**Modification to the Teys Australia Beef Abattoir (DA220-07-2002-I-Mod-12)
Request for additional information**

Attachment 1: Request for additional information

Request for additional information

14A201 - 8

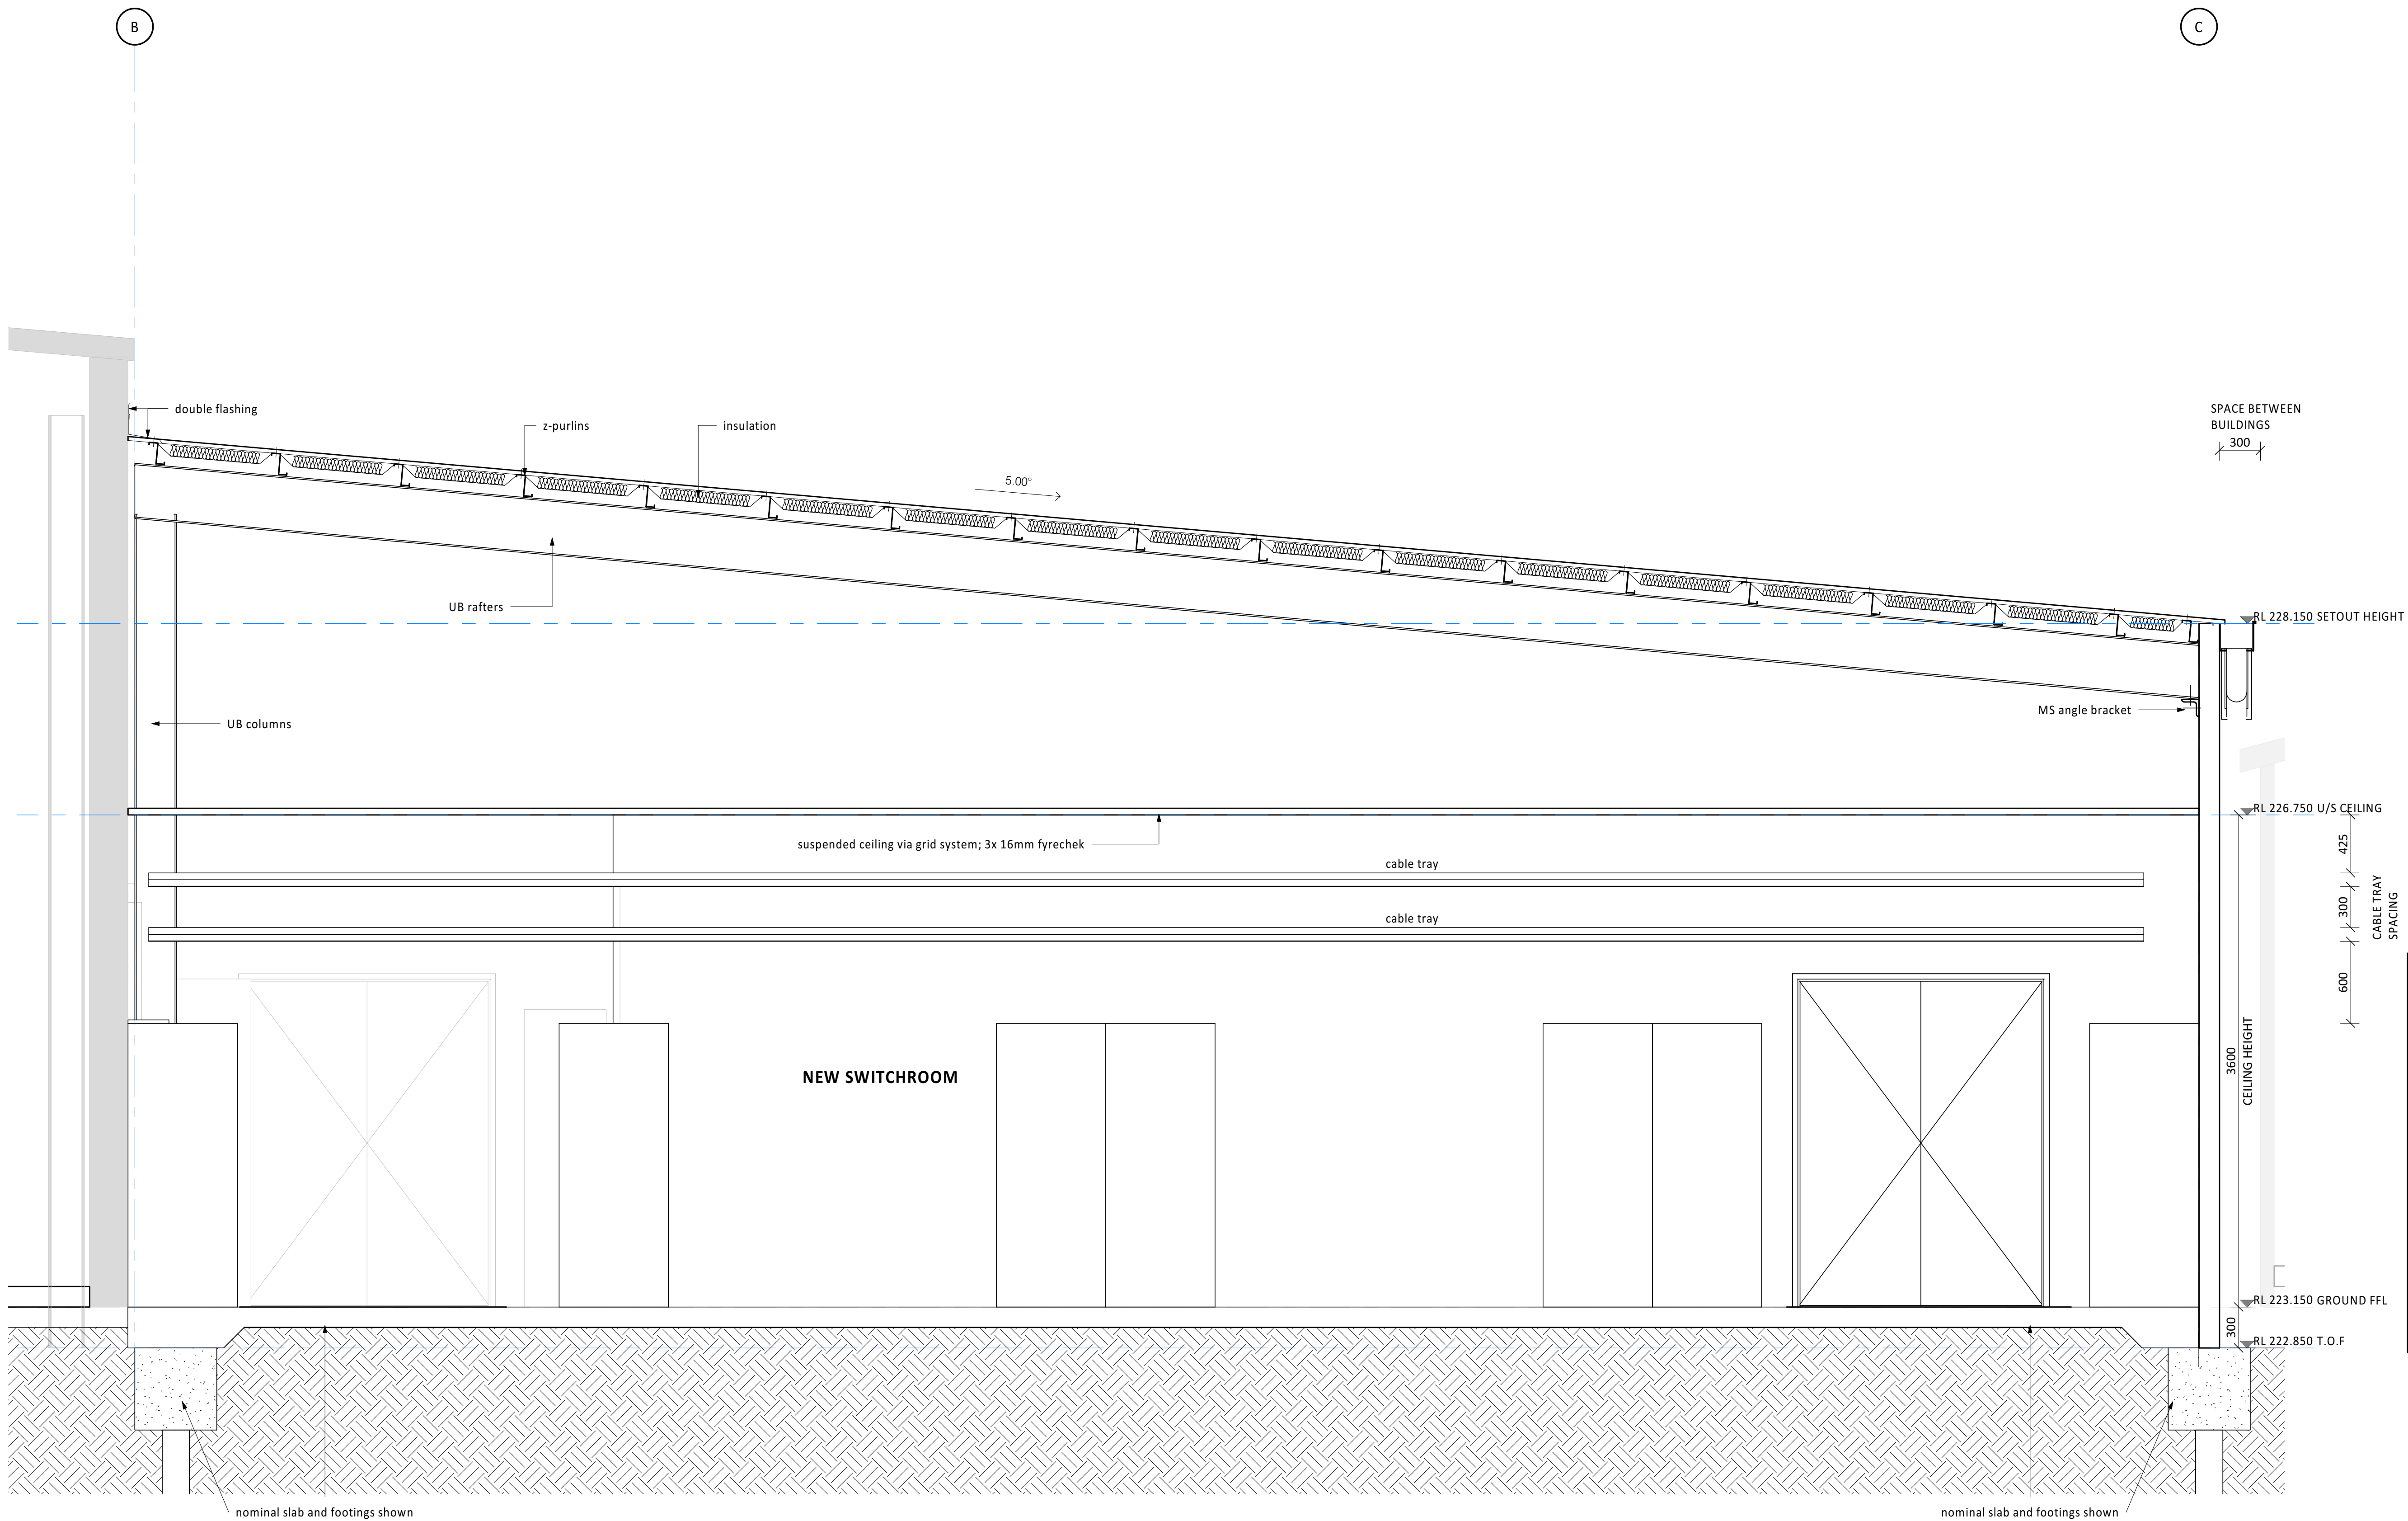
- The Modification Report states that one new roller door (3.0m x 2.4m) is to be constructed. However, submitted architectural plans (plan No. 14A201.1) depict two roller doors, one on the northern elevation (2.7m x 2.1m) and one on the southern elevation (3.0m x 2.4m). The Report should be updated to list the correct modified items of works.

35A201 - 15
NOT FOR CONSTRUCTION

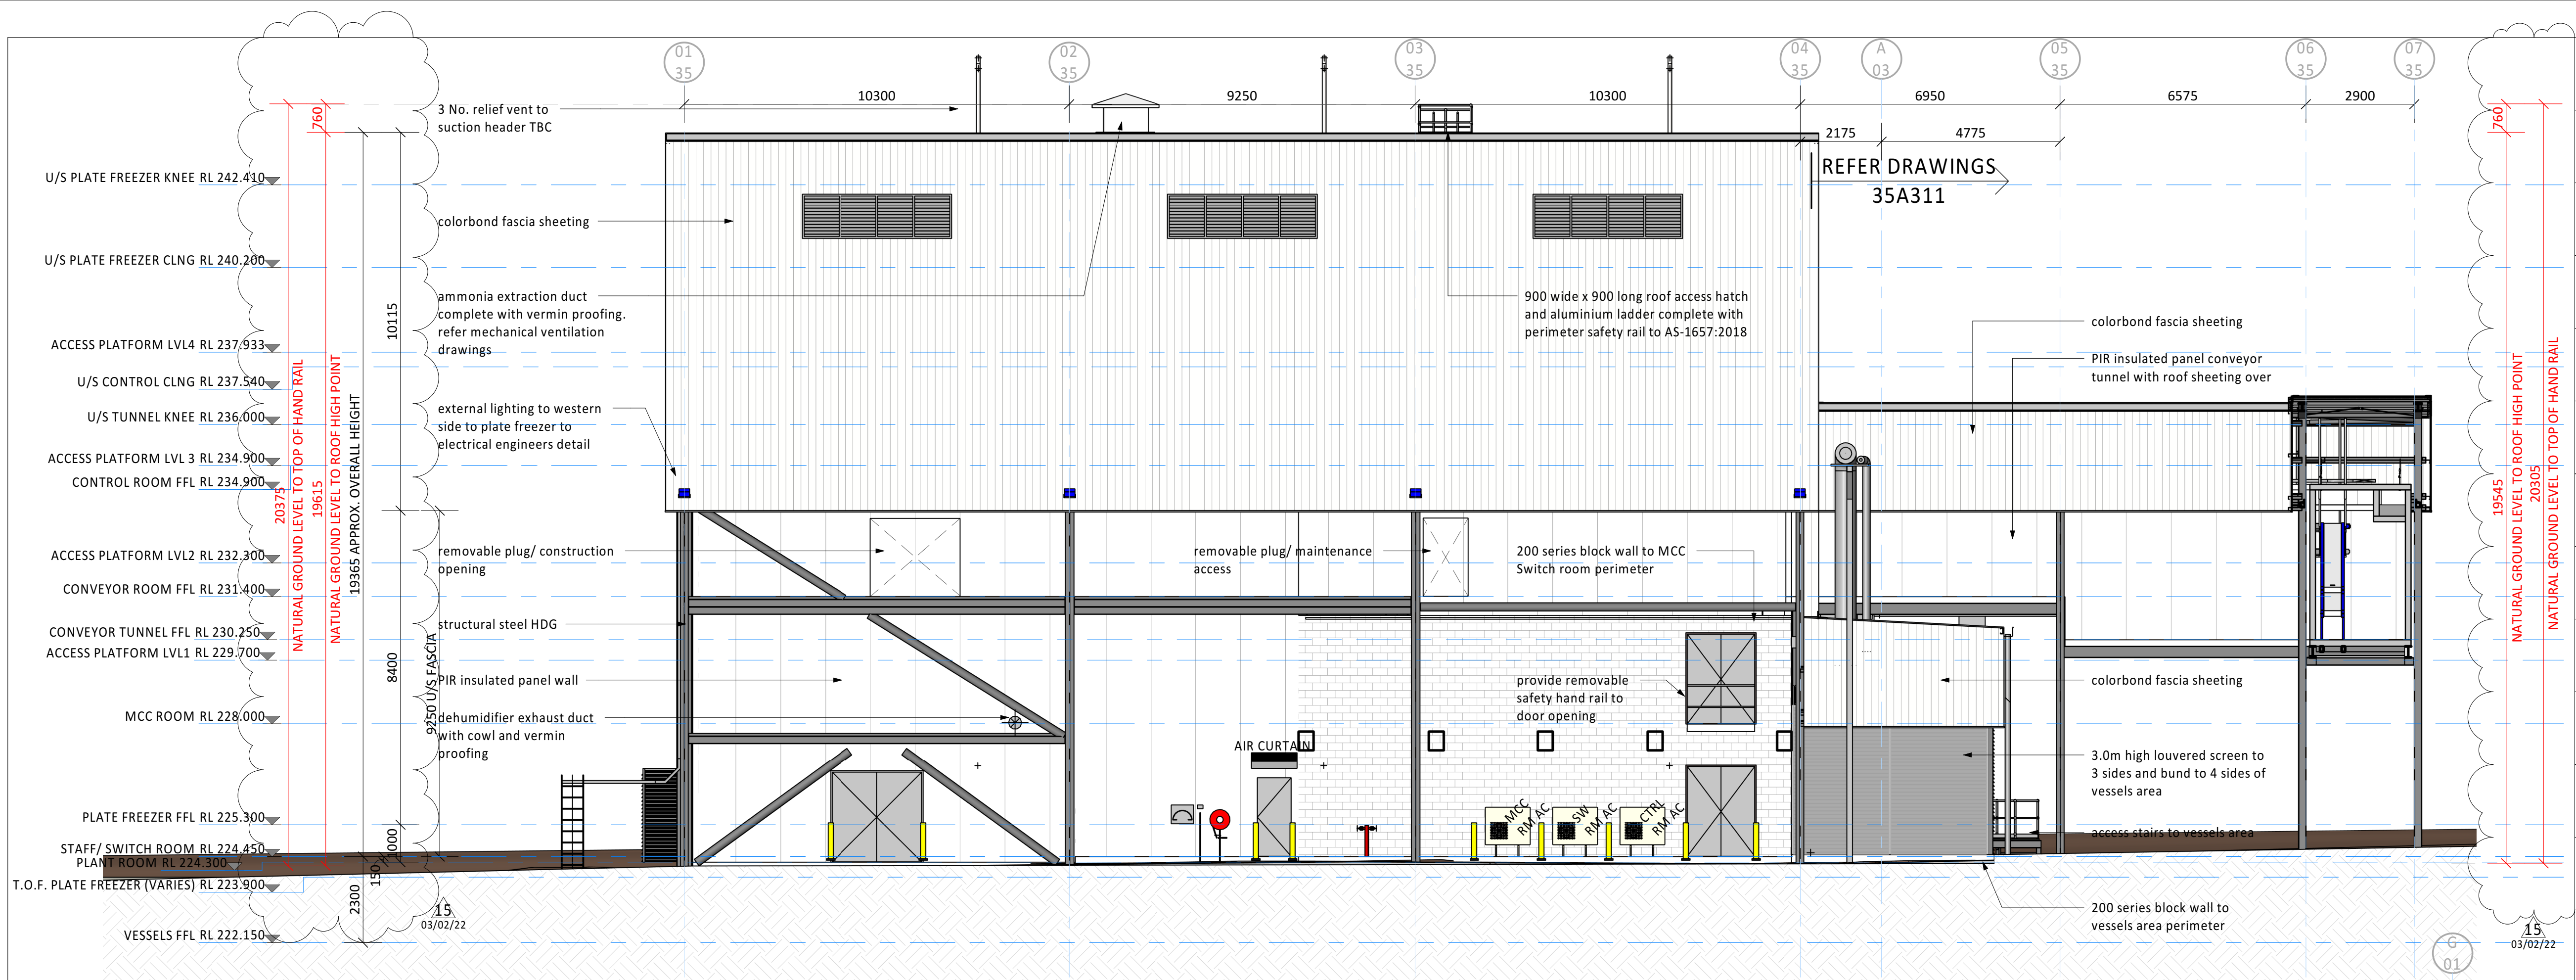
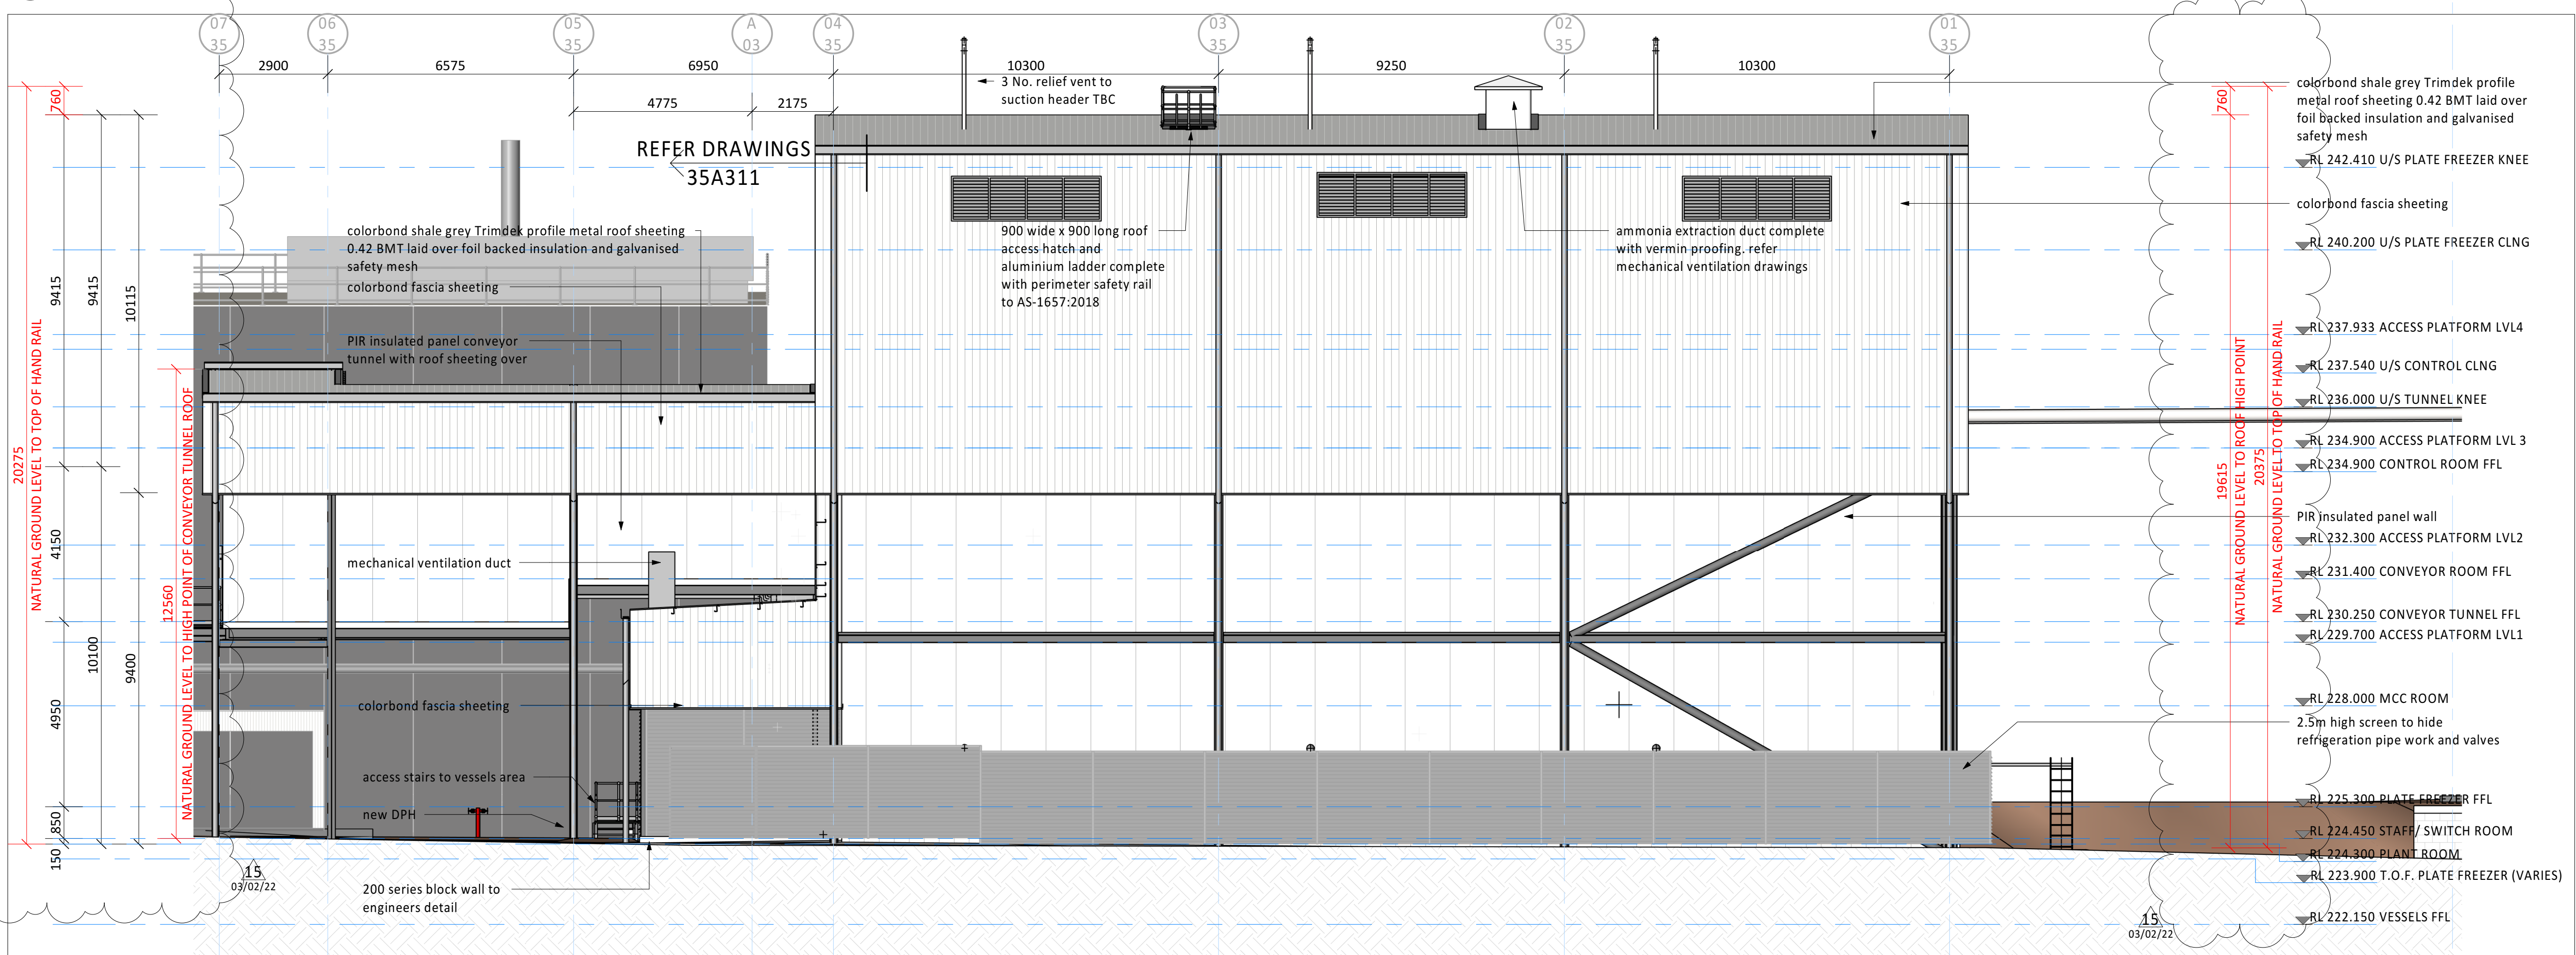
- The Report states that the building height of the proposed Plate Freezer building is 18.15m. Upon evaluation of the submitted drawings the proposed Plate Freezer building is higher than stated. Elevation plan (plan No. 35A201-7) shows a maximum building height of 18.15m, however this height is measured from RL225.3 (freezer plates) not from the ground level (existing). Please clarify this discrepancy.

- The height measurement has not included the indicative rooftop plant envelopes nor safety rails shown in the architectural plans. The Report is required to be amended to ensure the accurate building height is provided in accordance with the 'building height' definition included in the Wagga Wagga Local Environmental Plan 2010.
